From: Malcolm Hughes
To: [Jack Murphy](#)
Cc:
Subject: RE: Peppertree Quarry - Modification 5 Response to Submissions
Date: Monday, 18 February 2019 3:00:21 PM
Attachments: [image005.png](#)

Thank you for providing WaterNSW with the opportunity to review and comment on Part A of the Response to Submissions (RTS) for the Peppertree Quarry modification application (06_0074 Mod 5).

Figure 5: Surface water management system for the WOE and SWOE

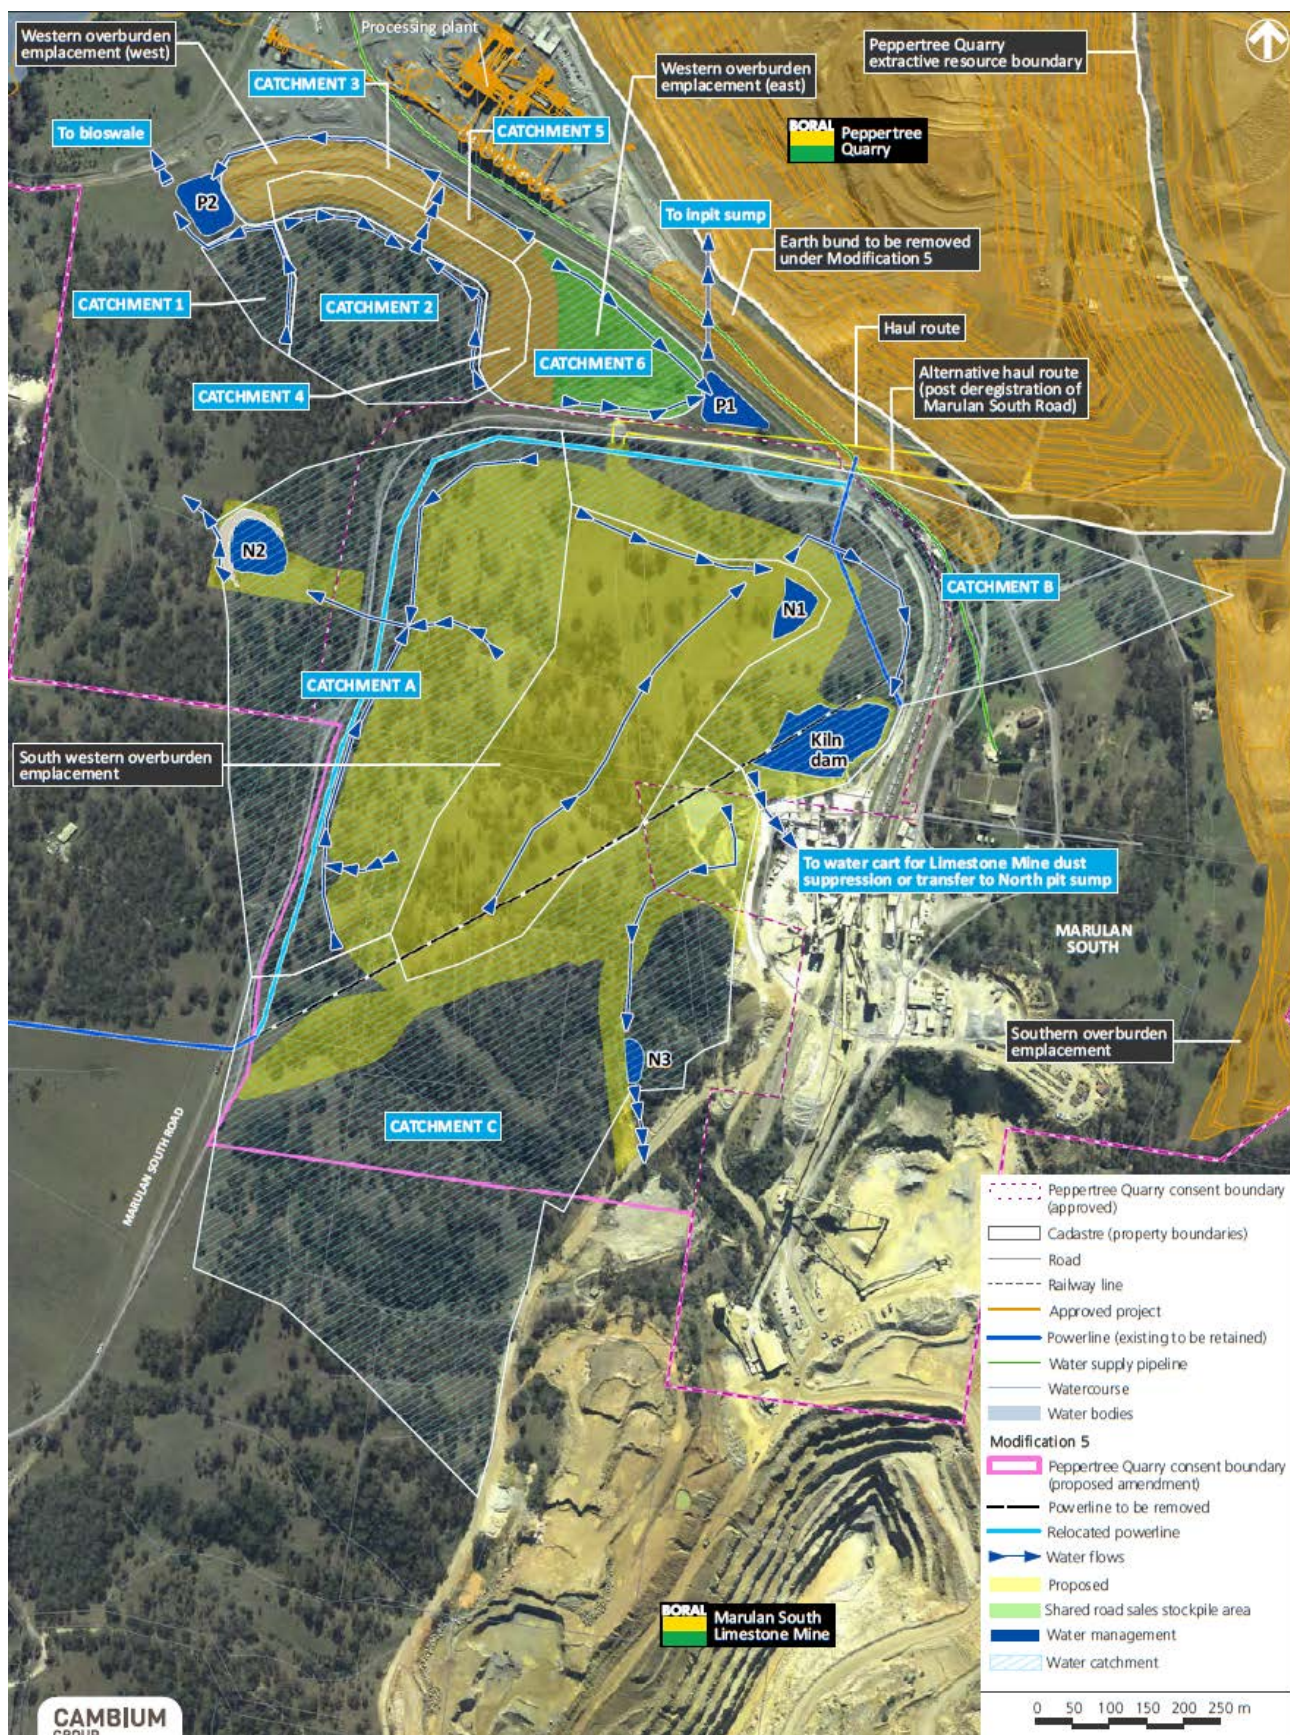
WaterNSW has reviewed the RTS and notes that while our comments on the long term stability of the landform of the South West Overburden Emplacement (SWOE) have been considered, the project has not been amended to address these comments. We note that the RTS acknowledges that the material would be very erosive.

To address the long term stability issue of the SWOE, WaterNSW recommends that the Department require the revised Water Management Plan include:

- regular monitoring of the stability of the SWOE
- updates to the proposed management measures depending upon the outcome of the monitoring
- the monitoring reports and any changes to management measures be provided to WaterNSW, and
- provision for monitoring to continue (and appropriate response measures) until such time as an independent expert confirms the SWOE is geomorphologically stable.

WaterNSW considers that the revision to the Water Management Plan should also consider erosion and sediment control measures specified in Appendix B, Table B.1 of Soils and Construction Volume 2C – Unsealed Roads DECC NSW (2008) including nearly flat slope of the berms and the dedicated drainage channels armoured in some way.
